REPORT on the IMPLICATIONS for EUROPEAN SITES

Proposed Connah's Quay Low Carbon Power Project

Planning Inspectorate Reference: EN010166

05 May 2026

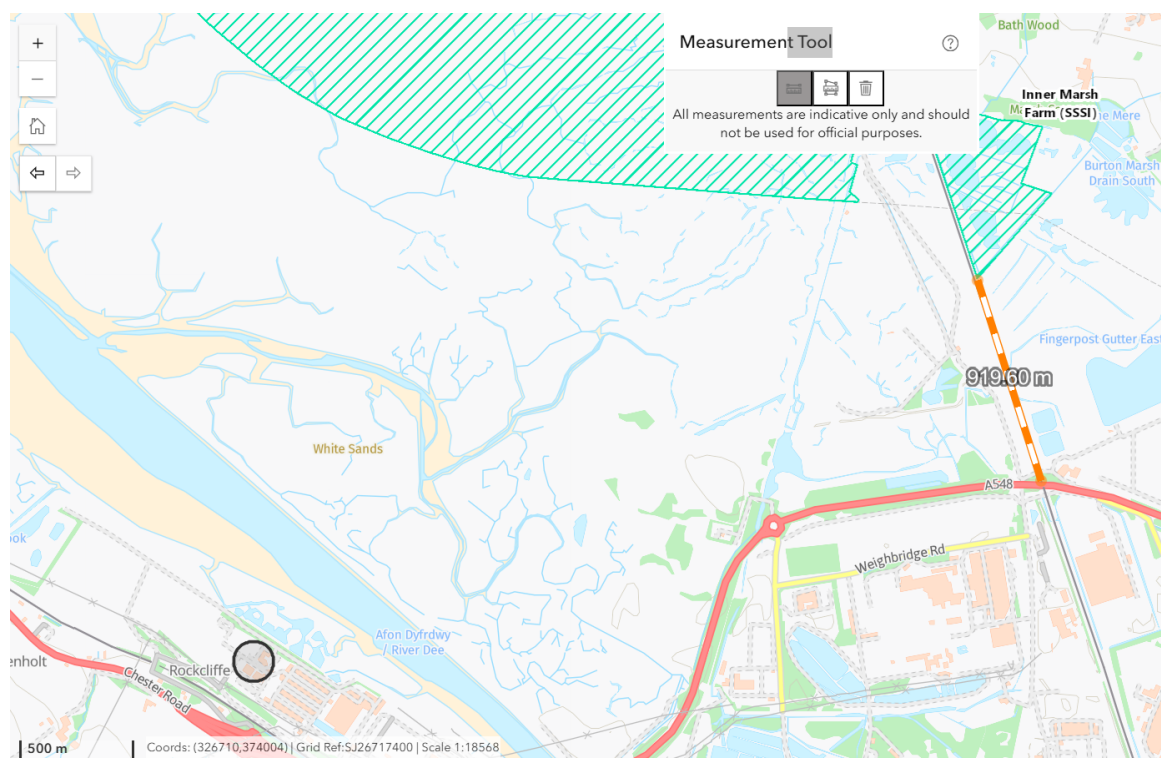
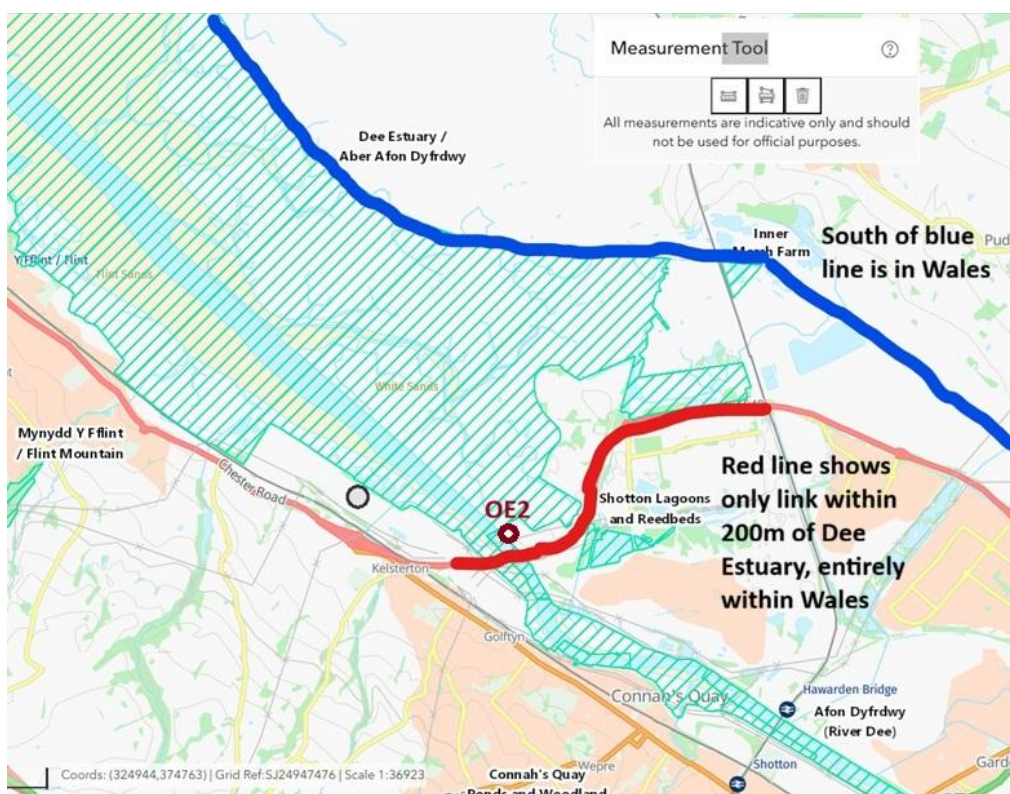
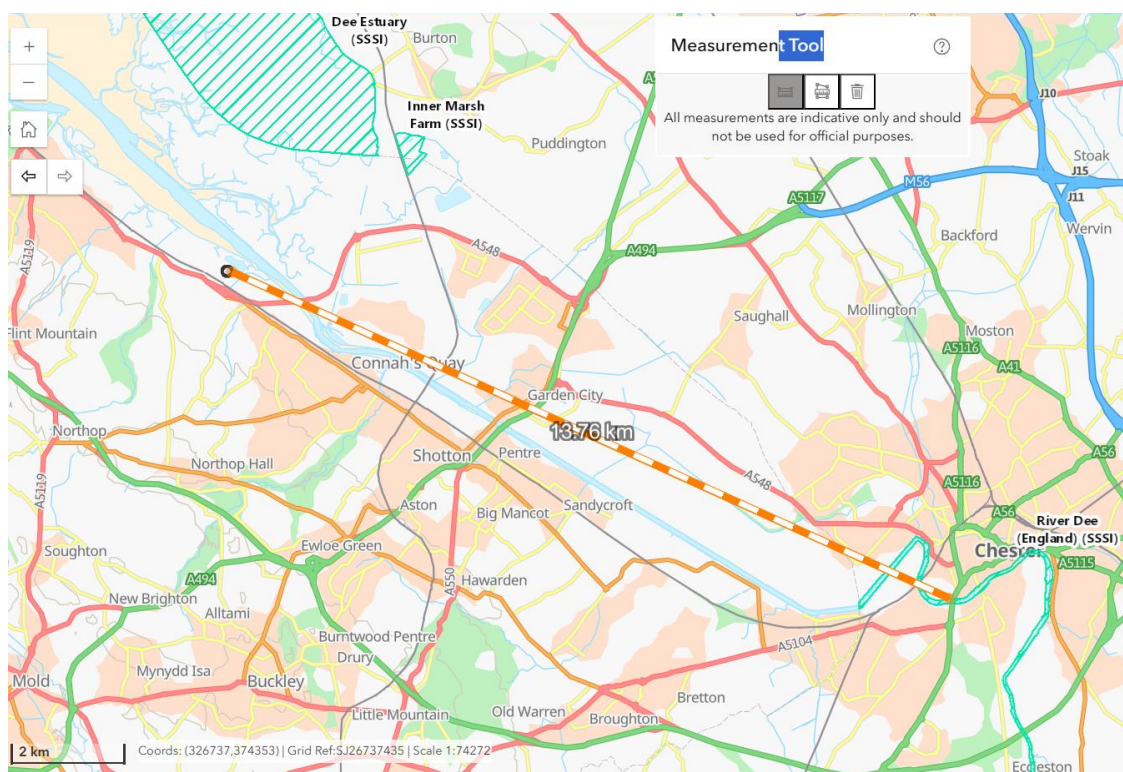
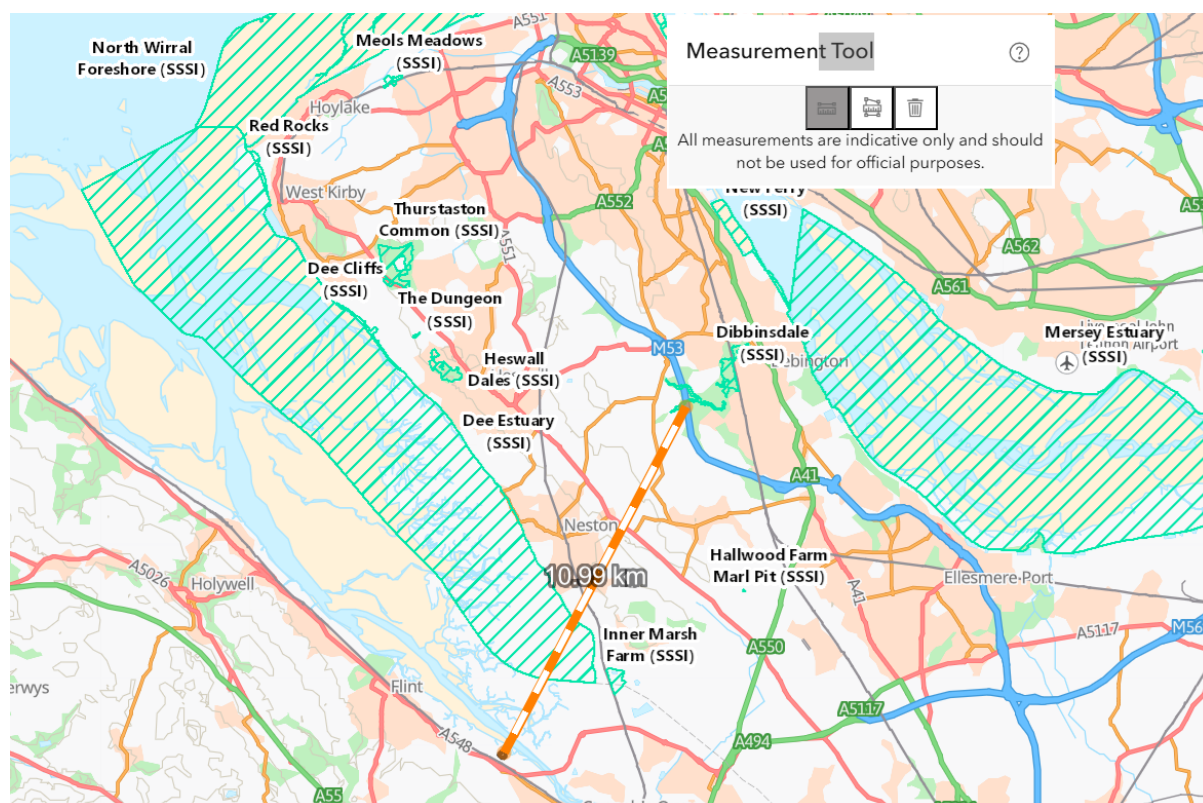
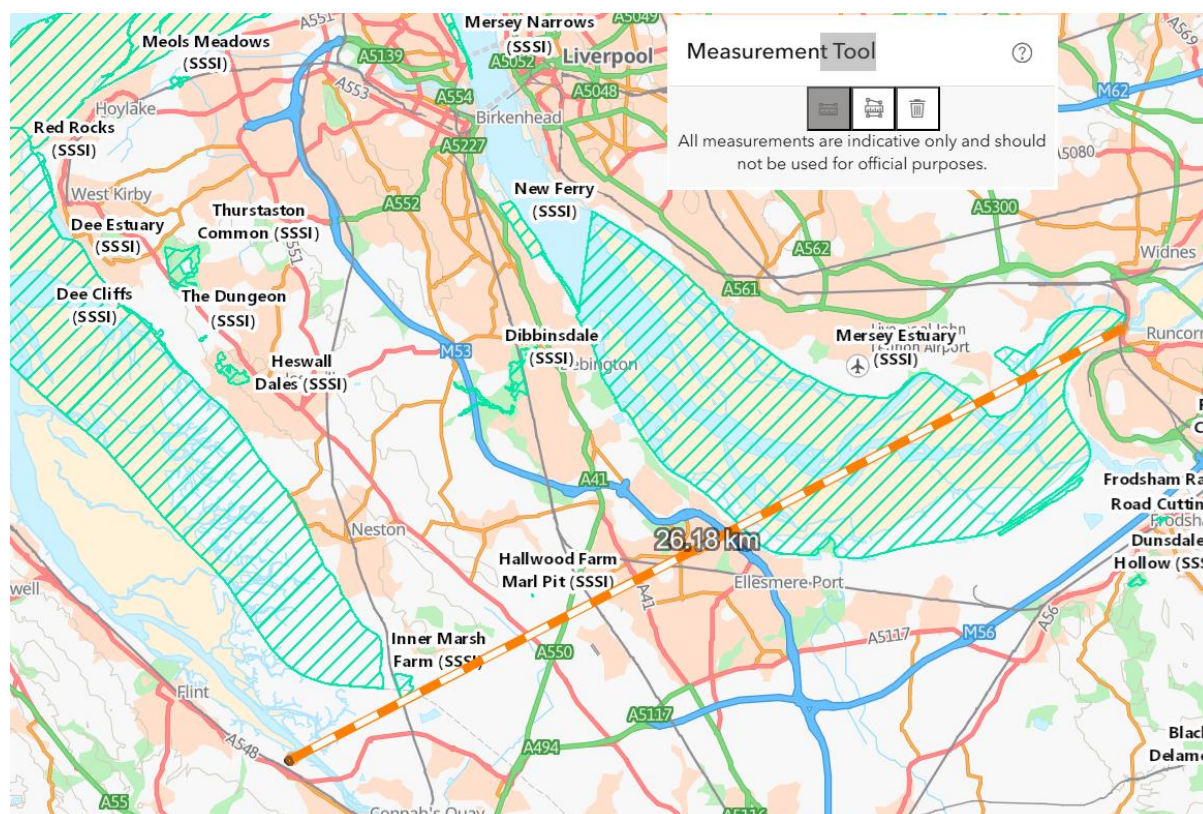
2.3.1 Section 8 of the RIHRA [APP-253] detailed the applicant's approach to assessing in-combination effects. The projects included in the in-combination assessment were detailed in section 10.4 of the RIHRA [APP-253]. No figure is provided in the RIHRA to illustrate the location of the projects included in the in-combination assessment.

RQ.2 [To the applicant] please provide a figure showing the location of the projects included in the in-combination assessment.
